Please upload email to AL/61/18/PDH

From: [REDACTED]
Sent: 13 June 2018 16:33
To: Planning.Responses
Subject: RE: Further Information Required on Your Ref: N/A Our Ref: AL/61/18/PDH

DWG NO
768/05
REV. A

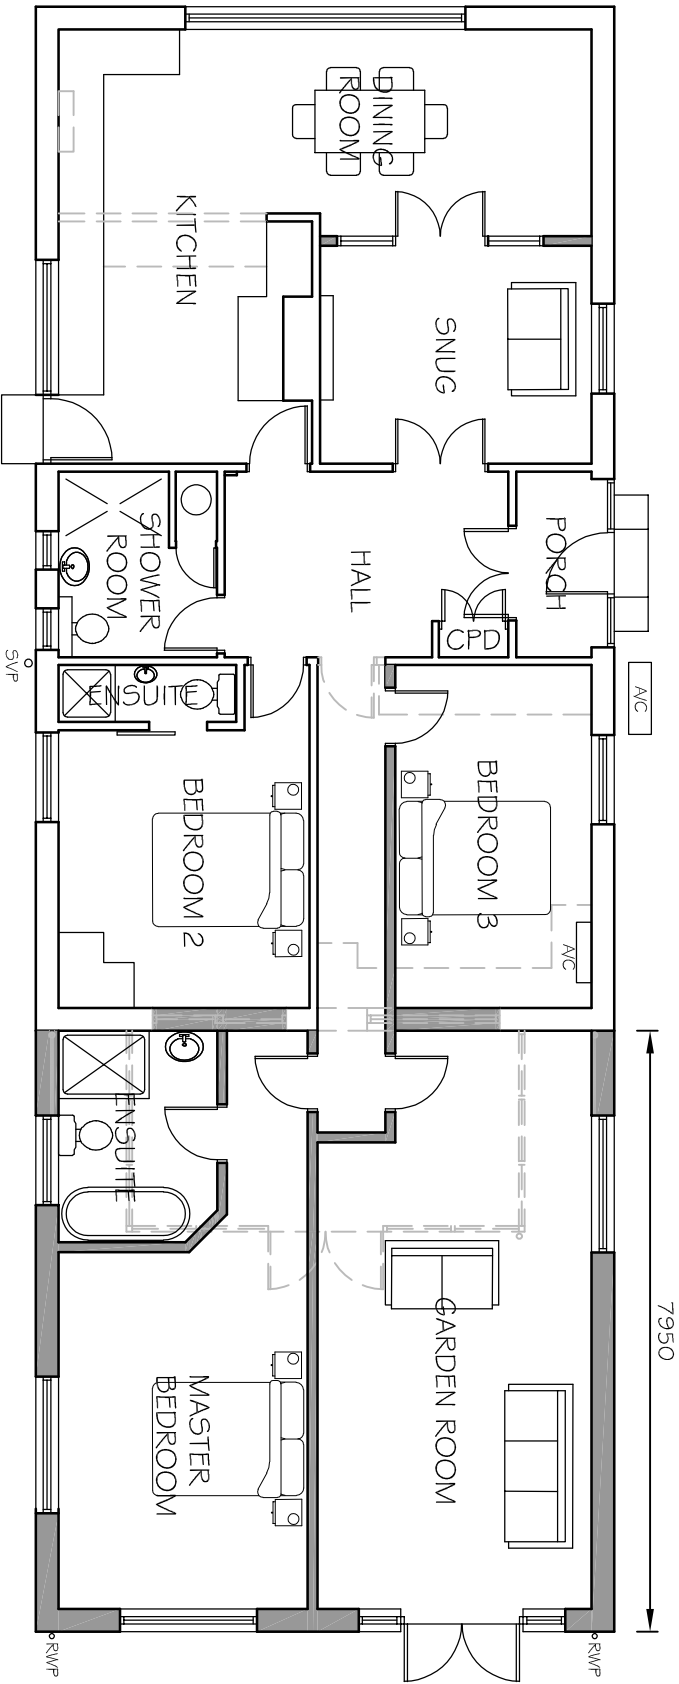
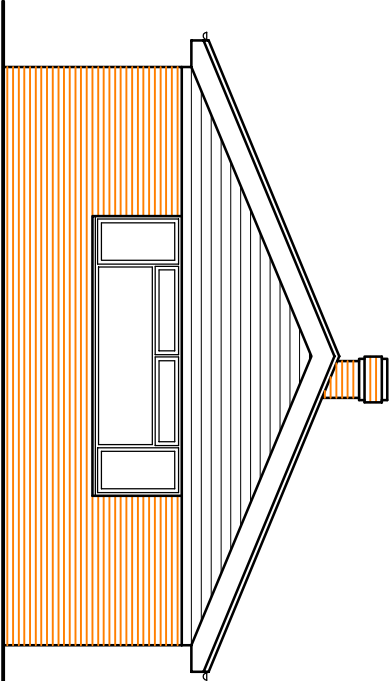
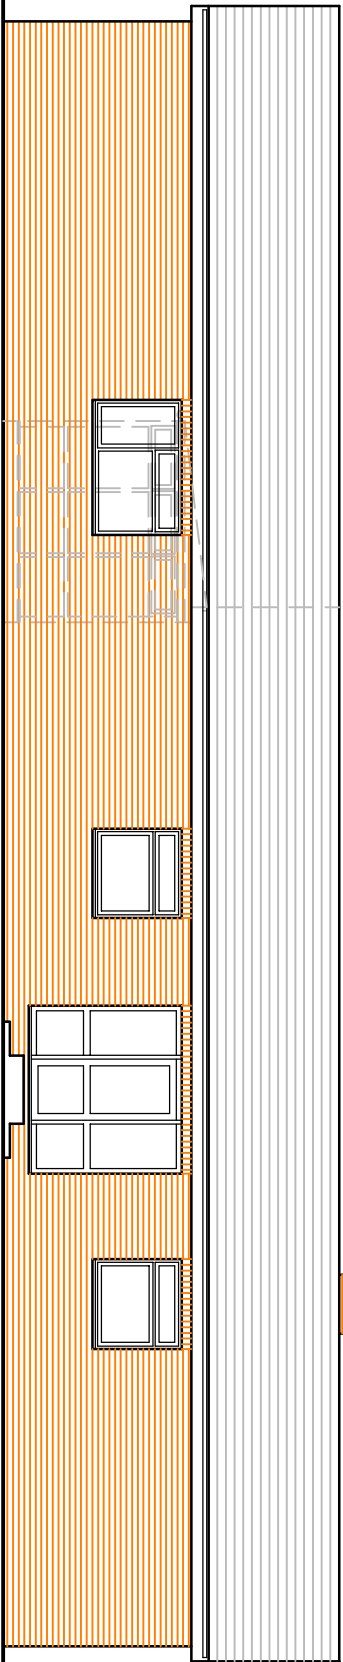
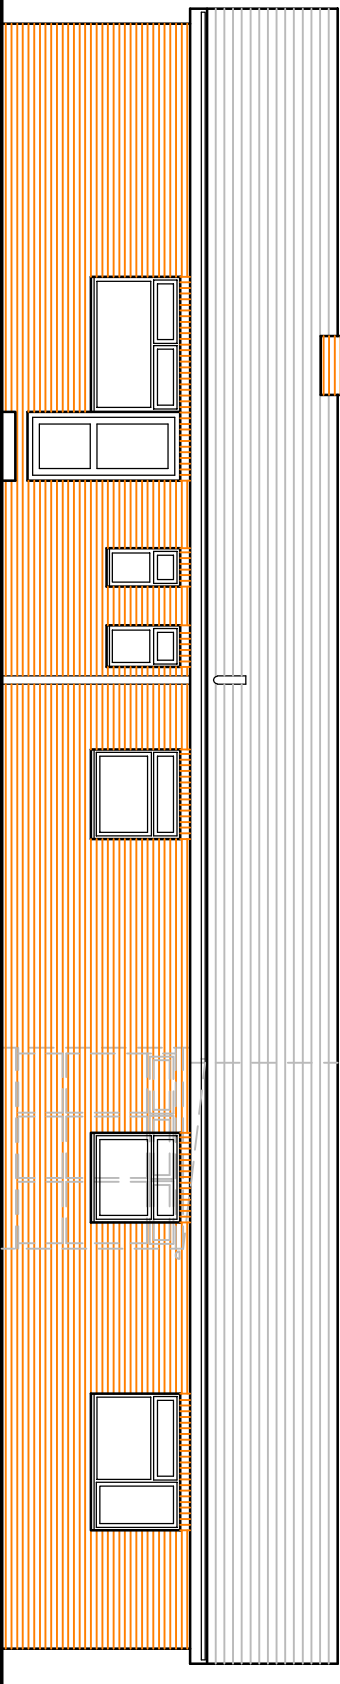
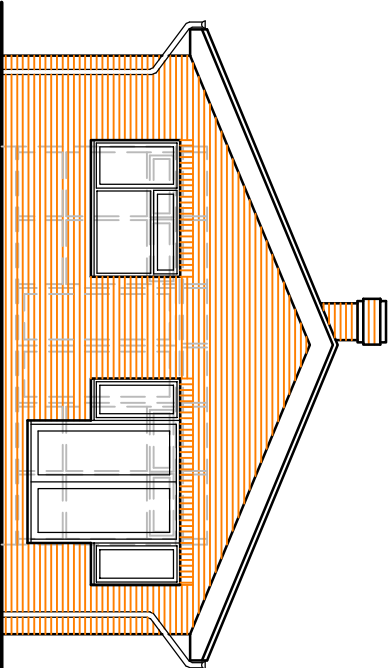
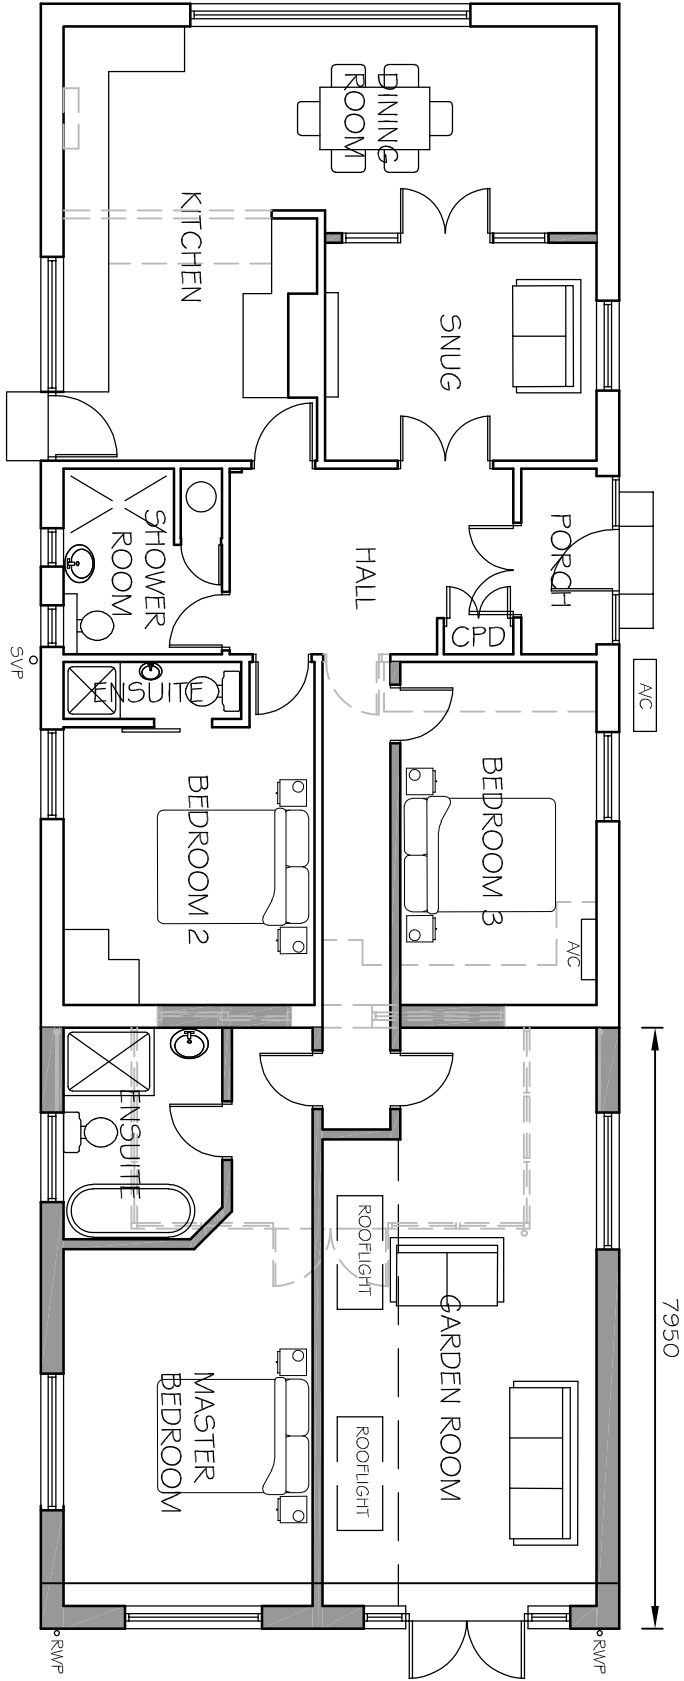
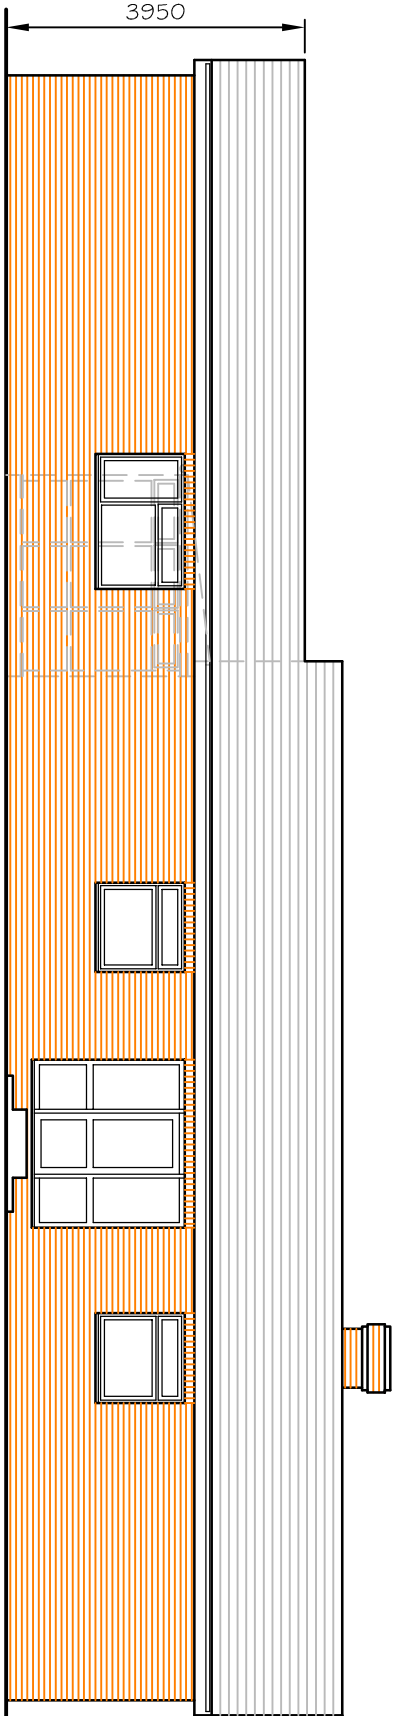
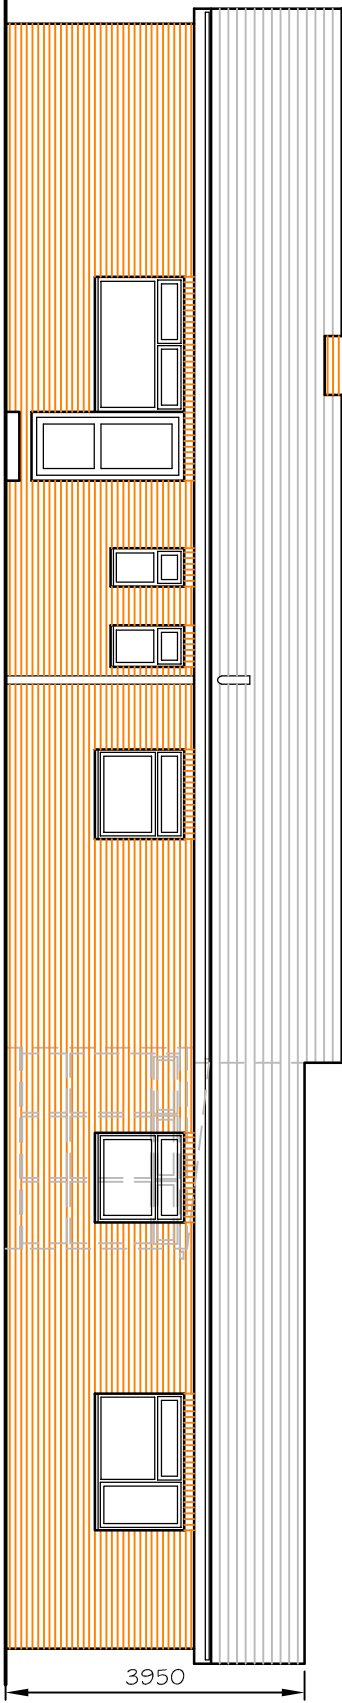
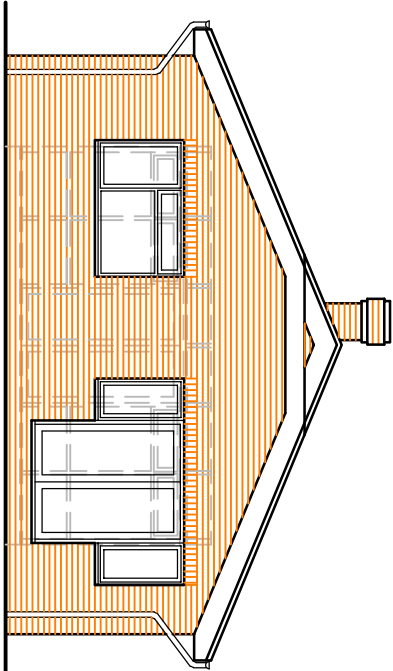
Thank you for your emailed letter dated 13 June 2018 and your comment that the extension should not exceed 4m in height. Please find attached drawing 768-05A which now shows the roof height of the proposed extension as no more than 4m.
